Helen Wellman
96 Hawthorn Road
Bognor Regis
PO21 2DG

Your Ref: OWPC22088
Our Ref: BR/302/18/PL 21-11-2018
Please ask for:
Stuart Corbey

1 x 2 bedroom flat and 2 x 1 bedroom flat to the east elevation
71 Hawthorne Road Bognor Regis

Thank you for your internet representation made on 6th April 2019 which has been recorded as '**an objection**' with the comments as follows:

SITE PLAN (Proposed) @1:200

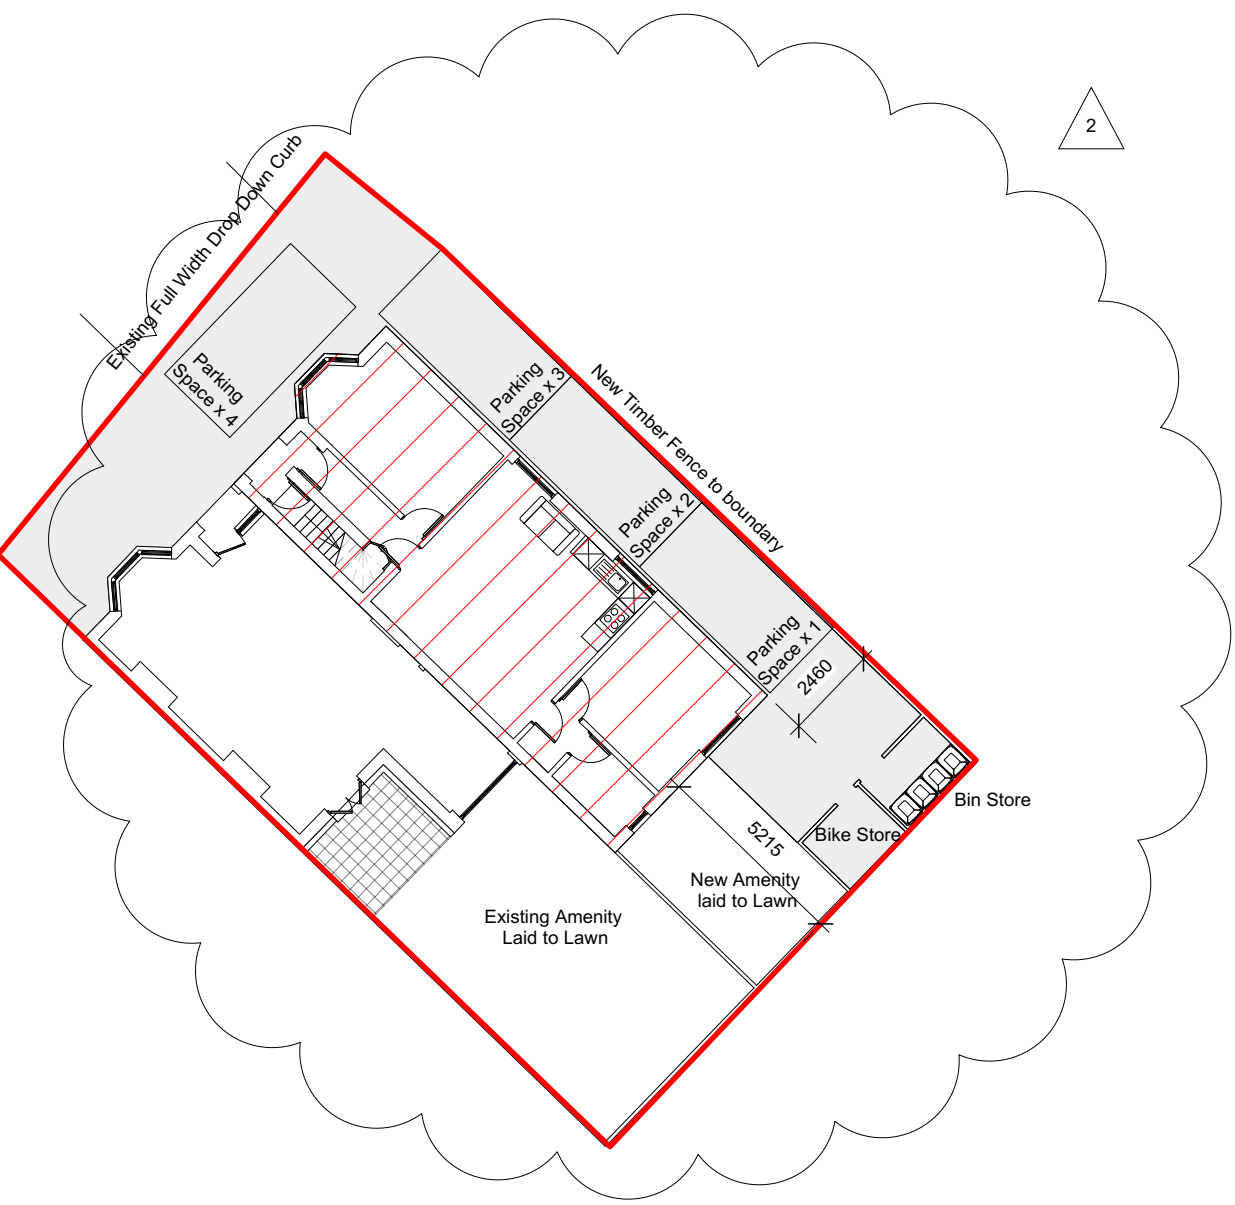
I'm still objecting based on the plans for parking. There could be potentially 6 adults living in the planned accommodation. All of whom may own a car or van. Therefore the planned on site parking clearly is not enough to accomodate 6 vehicles. Also the parking spaces to the side would mean that to get the car out at the back the other cars parked infront would need to move and I can not see that happening. It just won't be used and they will spill out onto the road which already struggles to accomodate Hawthorn Road residents' cars due to drivers from both Collyer Ave and Linden Road using it for their parking too. The drainage on the road infront of 71 is also currently inadequate and a large puddle forms there after any rain. This would need rectifying before creating any further hard surface which would lead to further run off.
